Report of the Head of Planning, Transportation and Regeneration

Address COPSE COTTAGE RICKMANSWORTH ROAD NORTHWOOD

Development: Conversion of garage to habitable use for use as an annex with alterations to elevations (Application for a Certificate of Lawful Development for a Proposed Development).

LBH Ref Nos: 70467/APP/2021/1223

Figure 5 : Layout comparisons

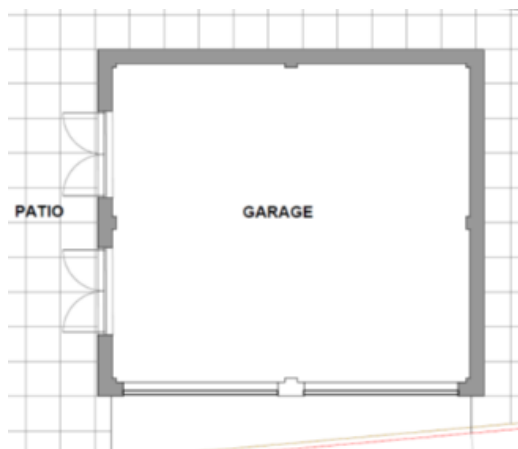
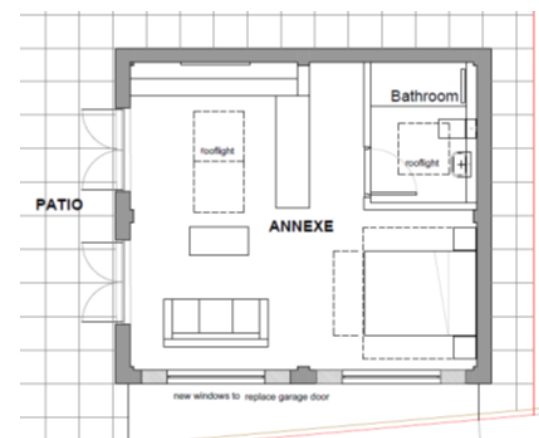
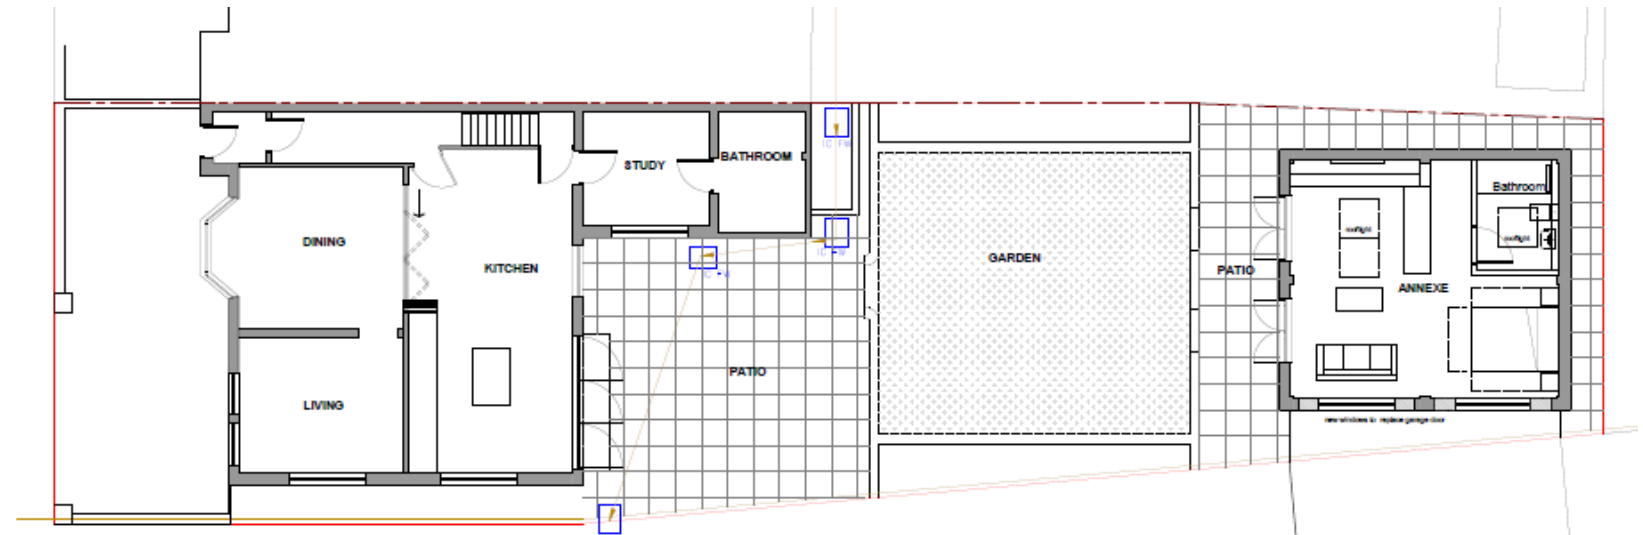
The use of the outbuilding as a self-contained annexe, with living area, potential kitchen area, bedroom and bathroom is not considered to be incidental to the use of the dwellinghouse and would be tantamount to the creation of a separate dwelling, capable of separate occupation and use. The proposed use of the outbuilding would not therefore fall

The use of the outbuilding as a self-contained annexe, with living area, bedroom, potential kitchen area and bathroom is not considered to be incidental to the use of the dwellinghouse and would be tantamount to the creation of a separate dwelling, capable of separate occupation and use. The proposed use of the outbuilding would not therefore fall within the conditions of Class E.

The applicant has stated in the application form the intended use of the outbuilding will be an annexe incidental to the main dwellinghouse. However, the plans show the presence of a potential kitchen area and it could be assumed cooking facilities

would allow the outbuilding to be used as a separate unit independent of the main dwelling.
